DECISION DELEGATED TO HEAD OF PLANNING

Application No: H07-0470-25 **Applicant:** Monkwise Limited
Proposal: Change of use of golf club function room to beauty salon - Retrospective
Location: Monkwise Golf Club West Drove North Gedney Hill
Terminal Date: 17th July 2025

Site Layout 1:500 scale

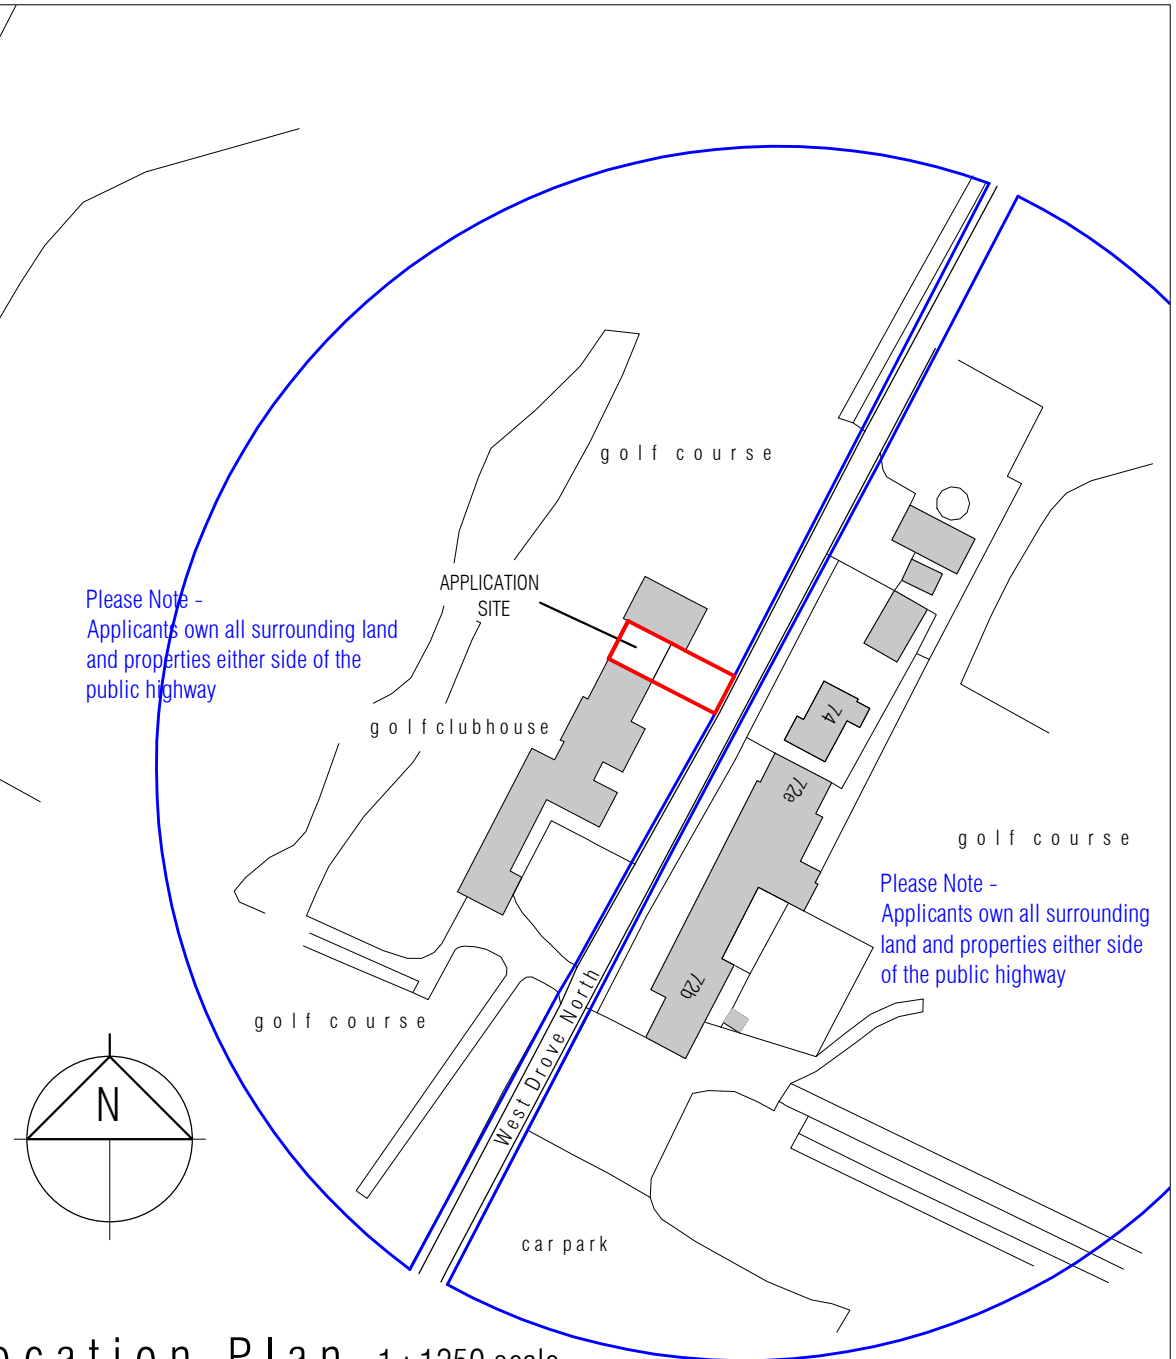
Lincolnshire County Council - Highways and SUDS: Only showing one parking space in the red outline but the application says 10+ with 2 disabled - justification is required to ensure that all the parking along here is sufficient for all the uses.

Lincolnshire County Council's Highways team have queried where the parking spaces are located as only one parking space appears to be indicated within the red line boundary. The Highways team have requested justification to ensure that the parking provision is sufficient. However, this is not considered to be necessary in this case as there is ample room for parking at the golf club on land that is within the ownership of the club. The proposal would therefore have an acceptable impact in terms of highway safety and as such, the proposal would accord with Policies 2, 3, 33 and 36 of the Local Plan, as well as Section 9 of the NPPF.
